Application by Highways England for M54 to M6 Link Road

The Examining Authority's written questions and requests for information (ExQ1)

Issued on 20 July 2020

LEGEND

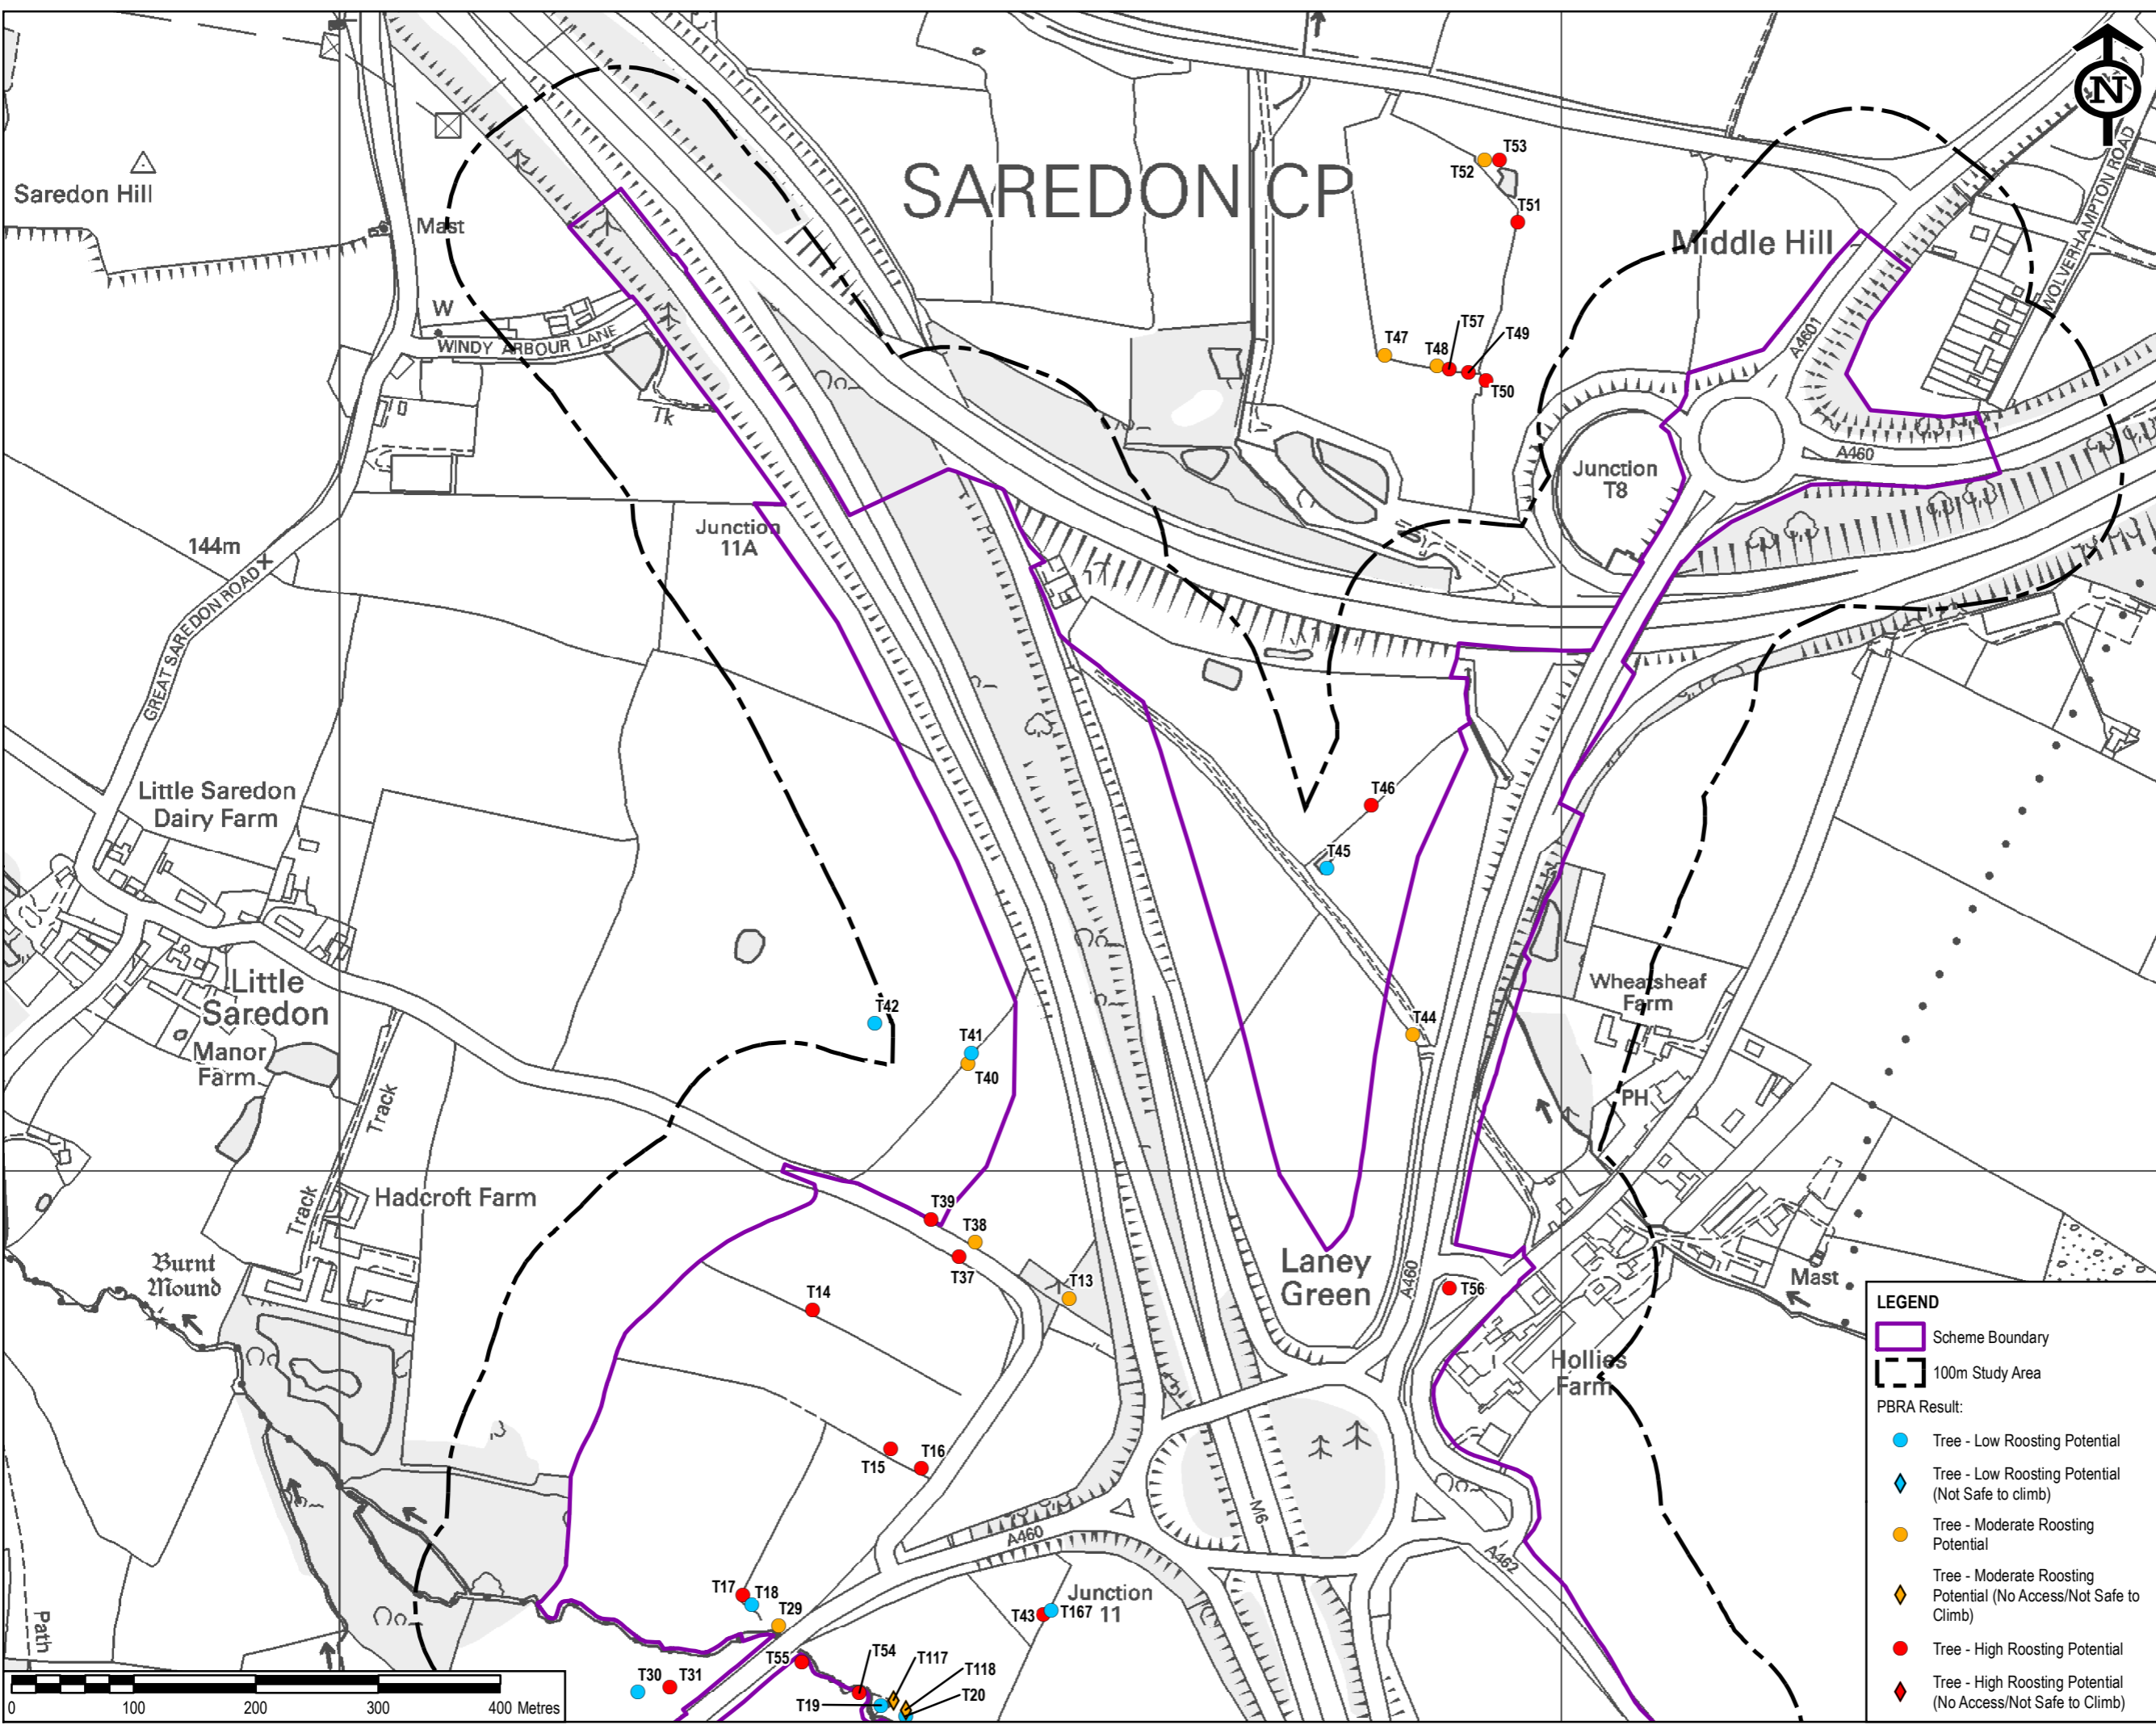
ExQ1	Question to:	Question:
		context?
1.3.4.	The Applicant	<p>Bats Paragraph 8.6.28 of Chapter 8 of the ES [APP-047] indicates two bat roosts within the boundary of the Proposed Development. However, in Figure 8.14 [APP-118] these two trees (T70 and T112) are given different classifications. Could this discrepancy be explained?</p>

Drawing Title  
**WORK PLANS  
 REGULATION 5(2)(J)  
 SHEET 1 OF 10**

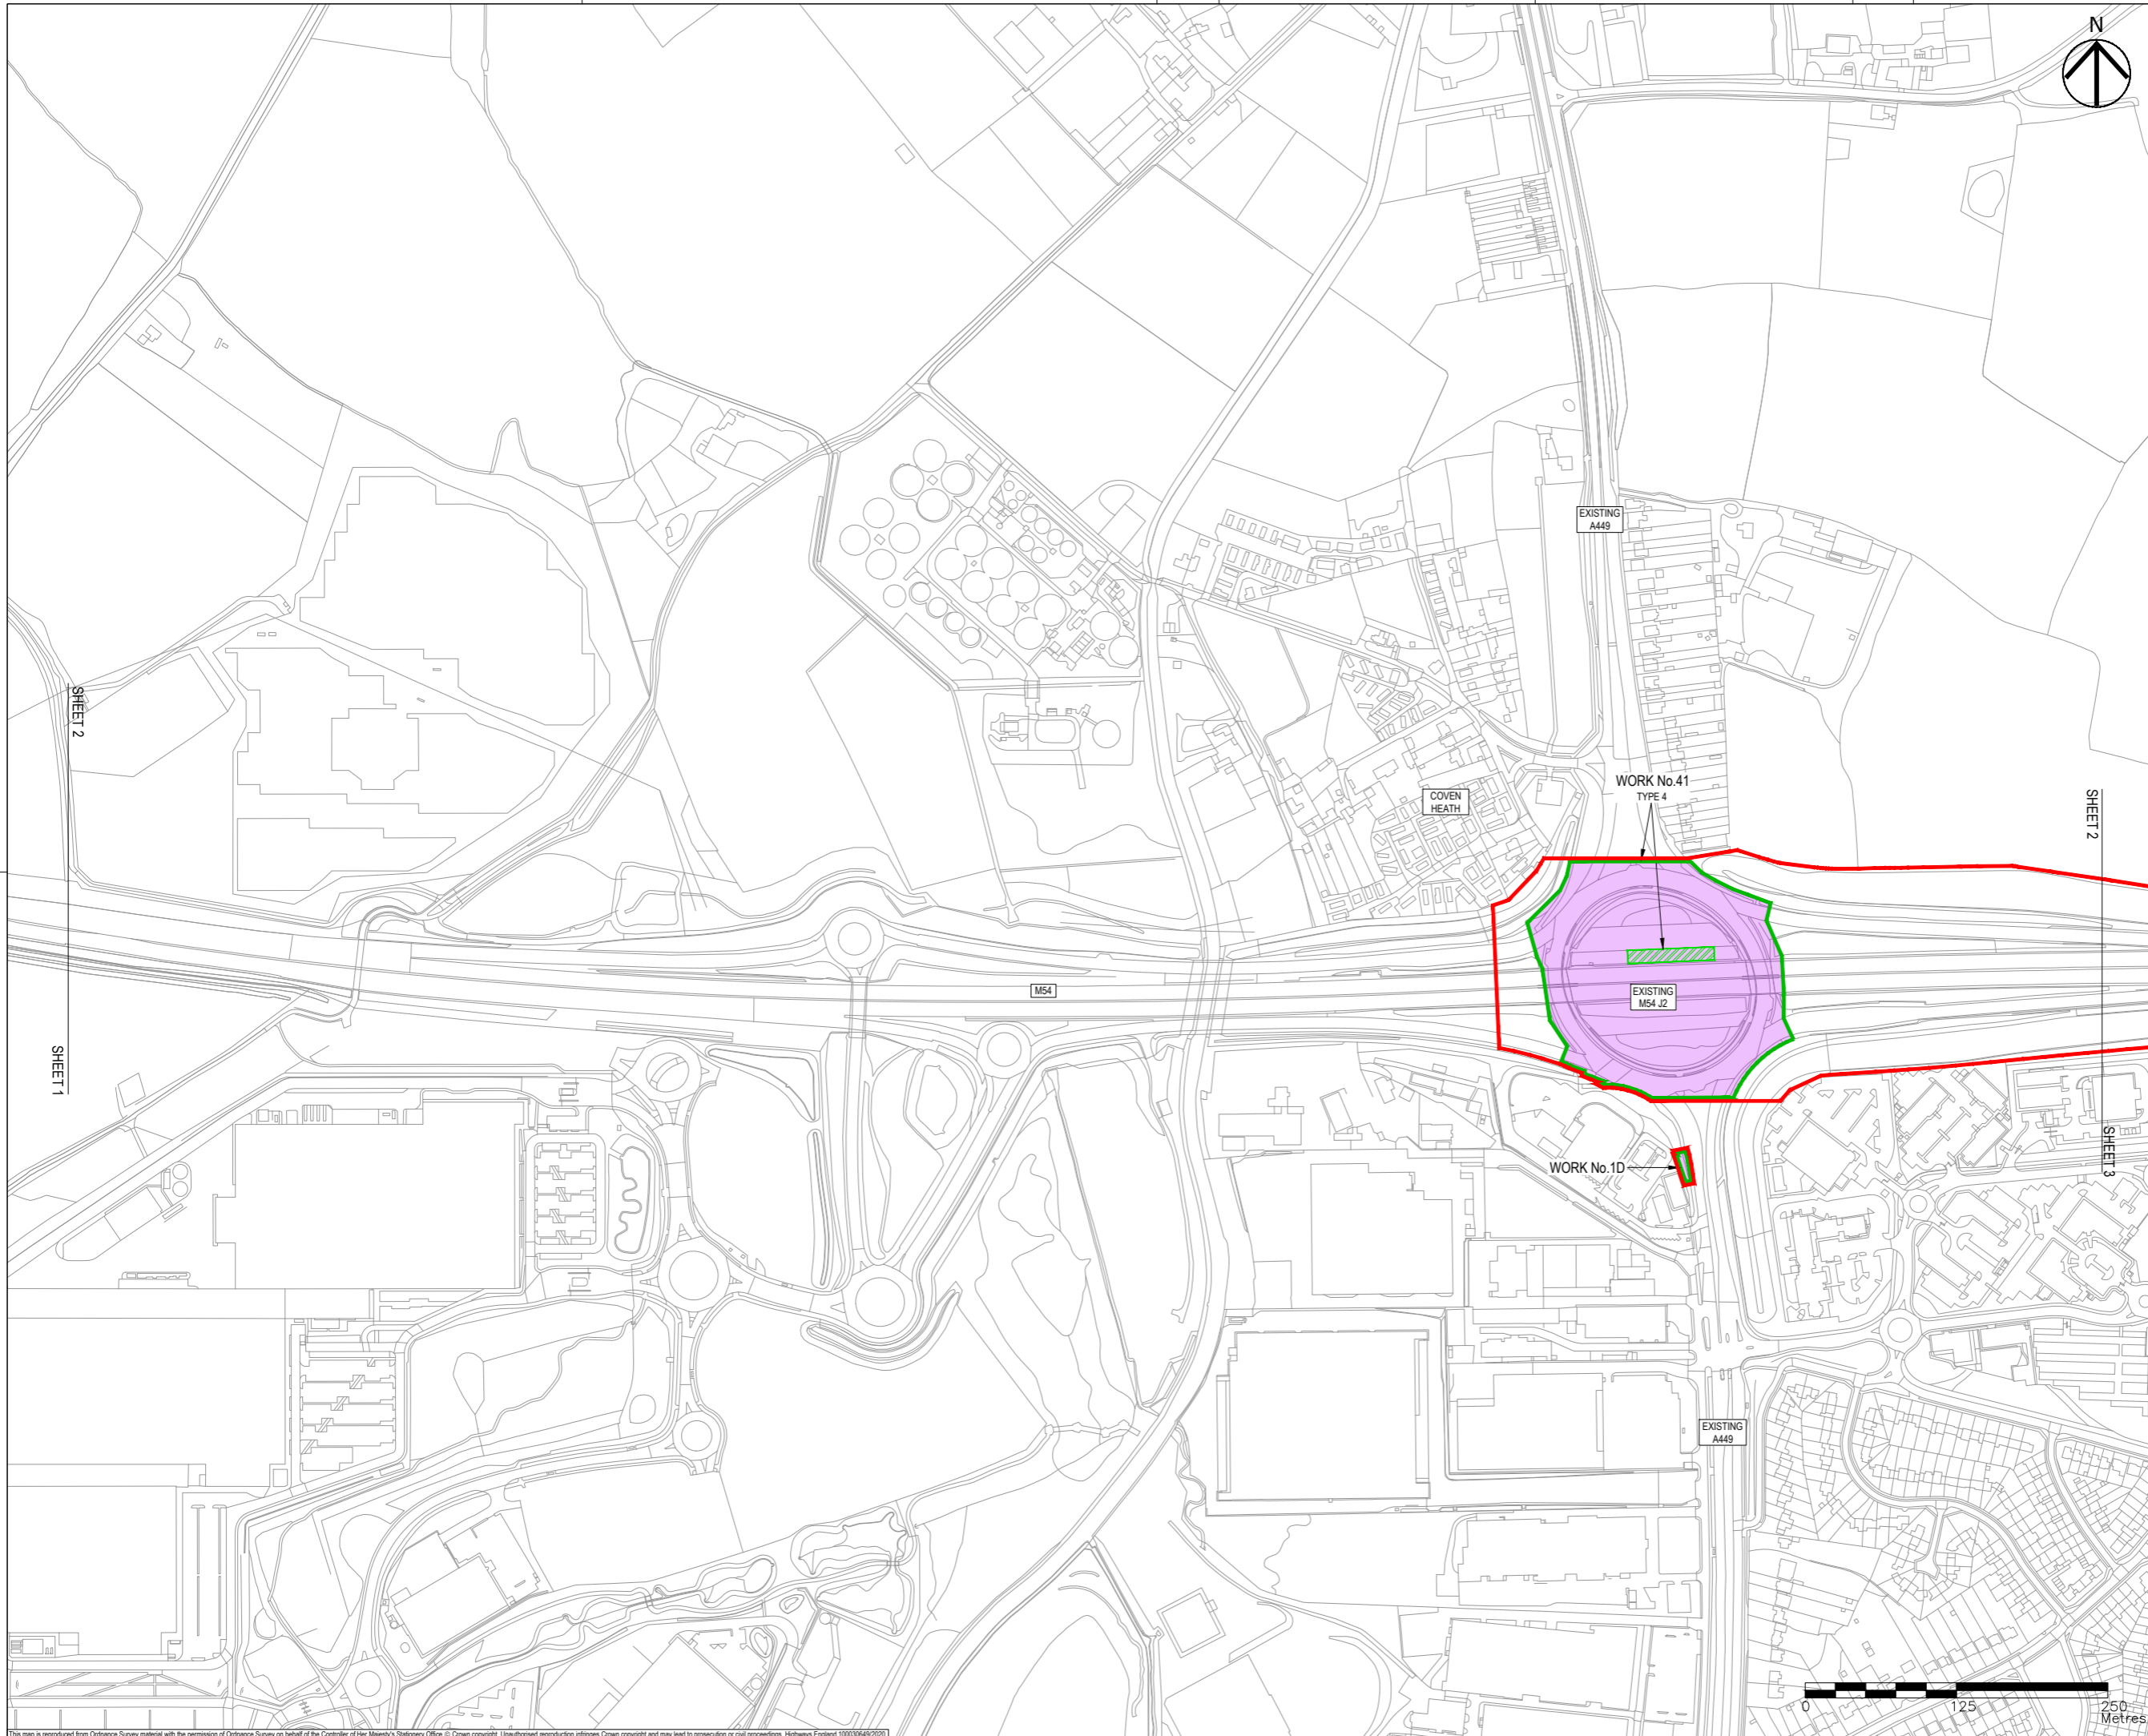
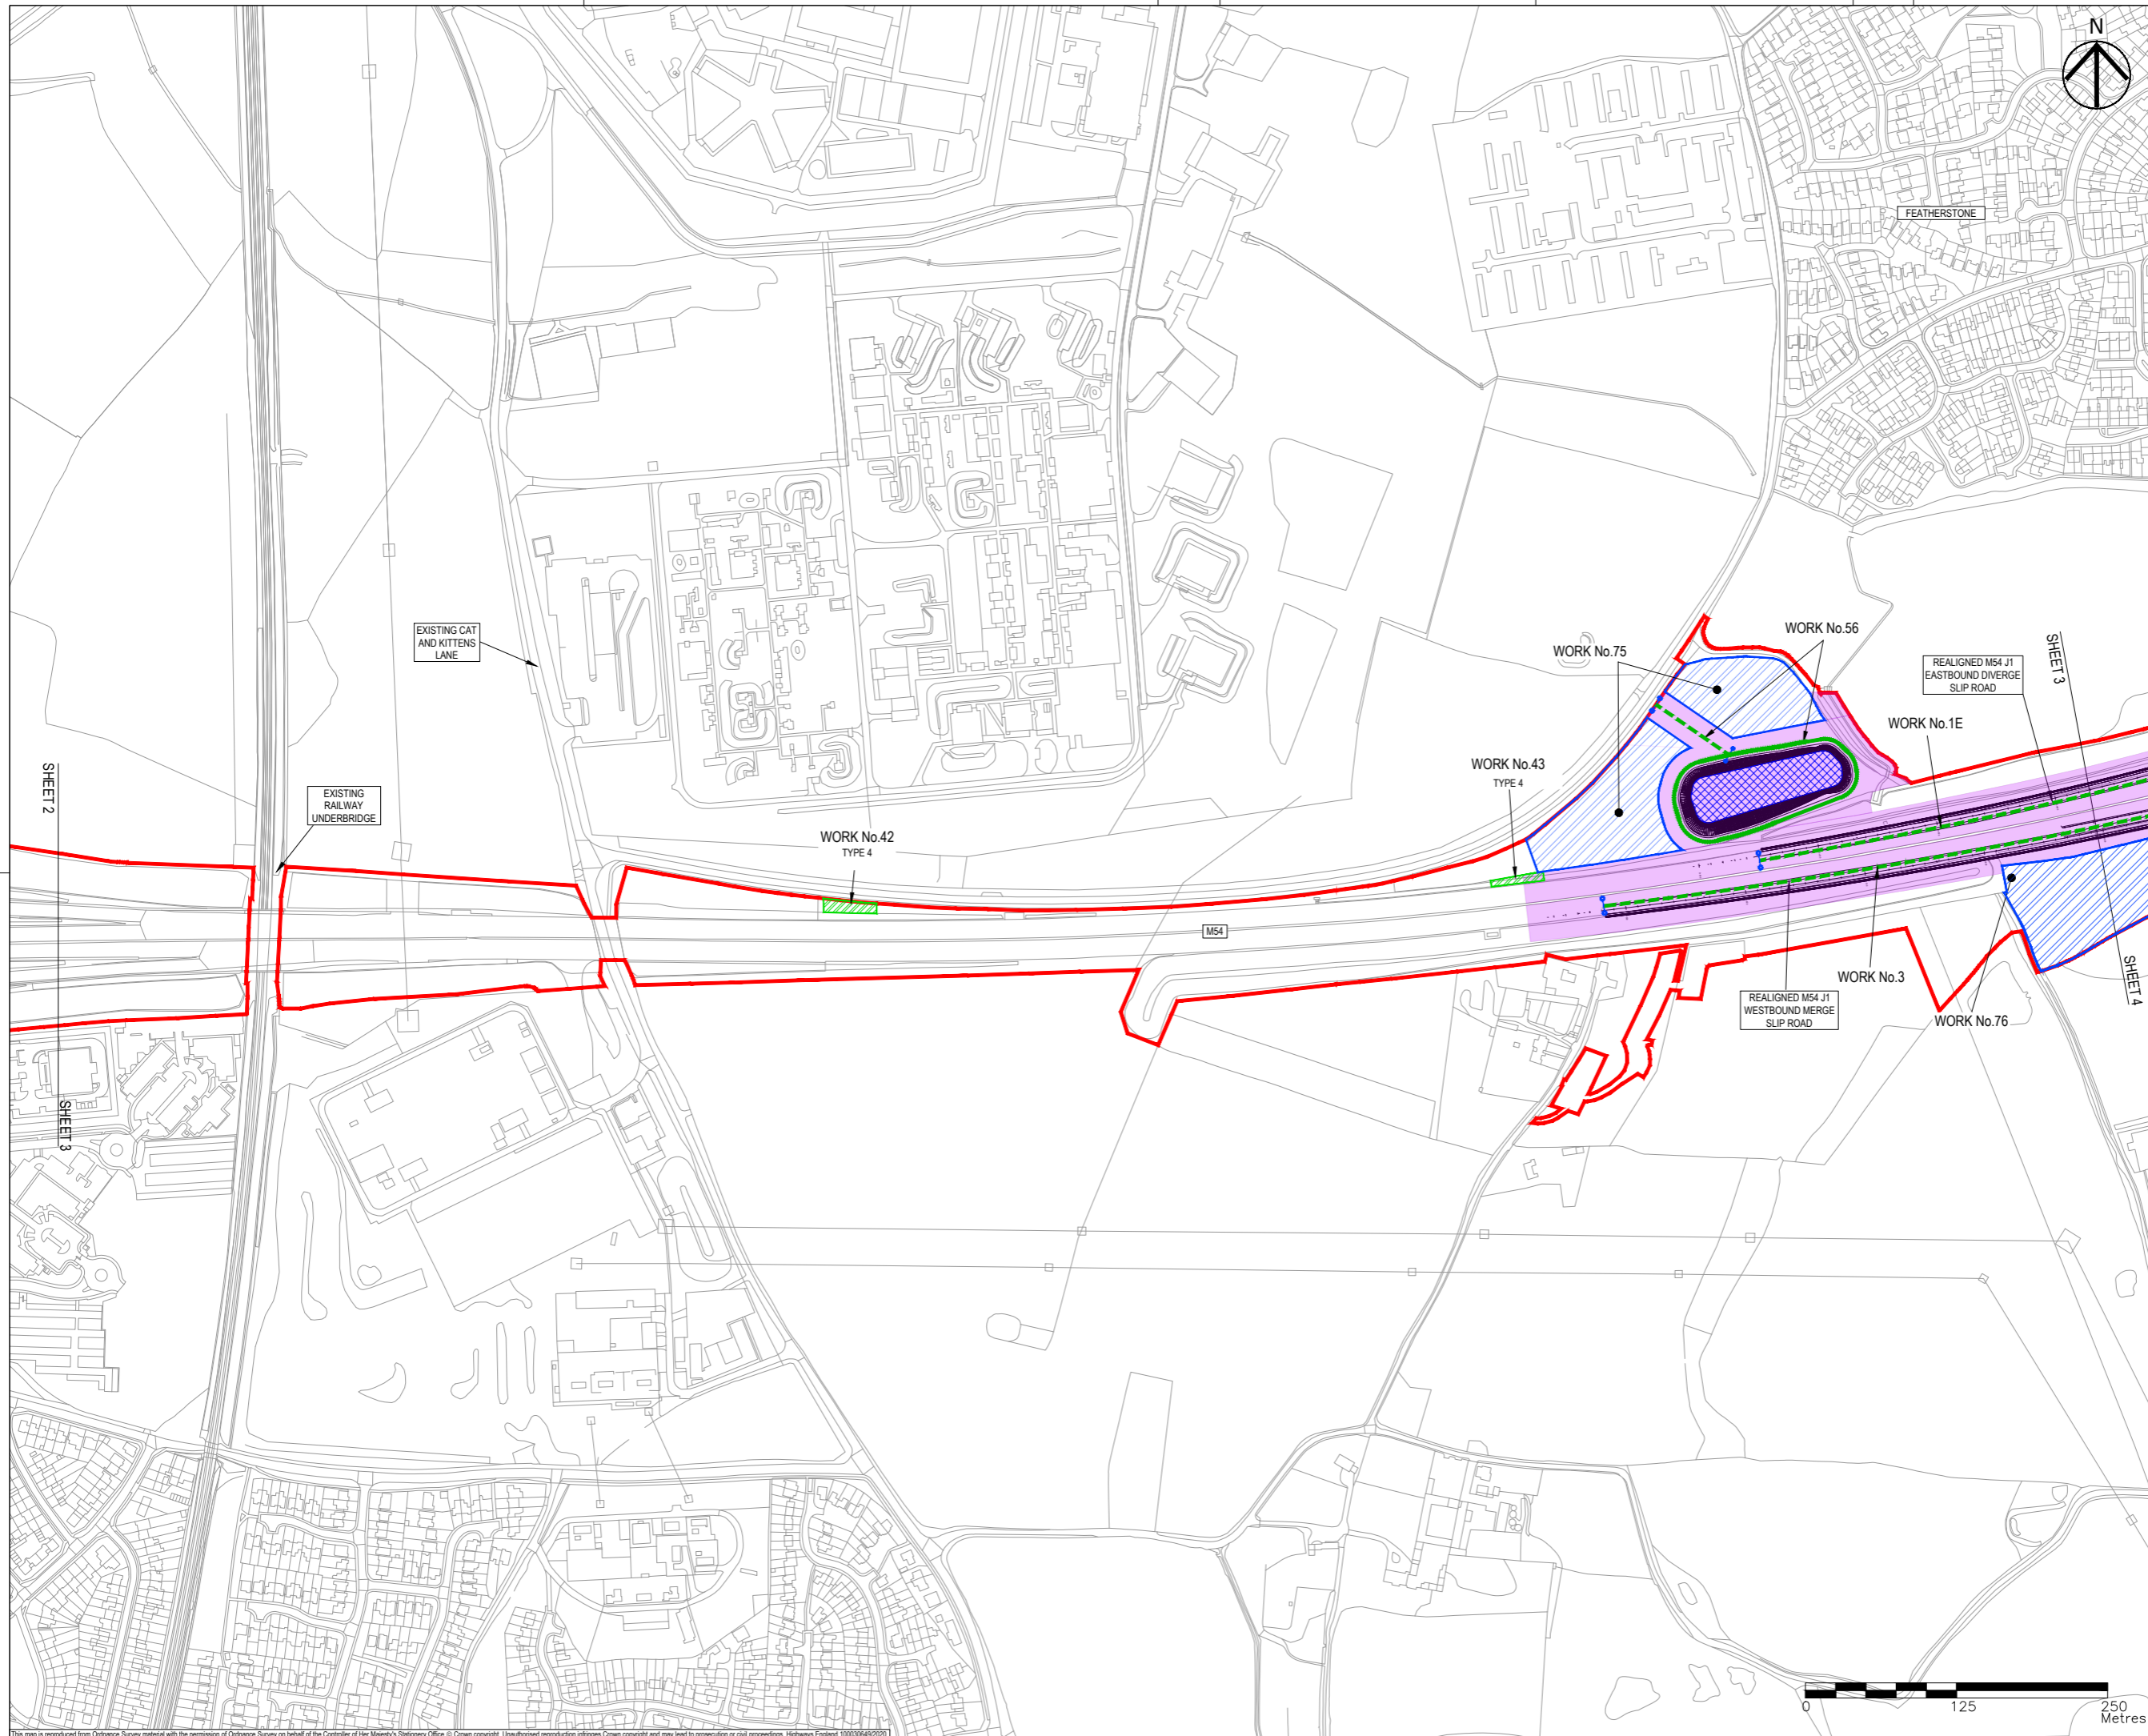
1.0.14	The Applicant	<p>Environmental Masterplan/Works Plans</p> <p>a) Can the Applicant clarify why certain areas of the Proposed Development as represented in the Works Plans red line boundary (within Sheets 1-3, and 6-10</p>

ExQ1	Question to:	Question:
		<p>[APP-057] to [APP-063], which include Works 1, 35, 41, 42, 51, 52, 53, 54, 55, 55A, 55B, and 55C) have not been fully represented in the Environmental Masterplan or in the Construction Works (ES Figure 2.9, [APP-065]) for the ES.</p> <p>b) Can the Applicant explain why these works are not represented on the Environmental Masterplan and the Construction Works plans and confirm that these works have been fully considered as part of the ES.</p>
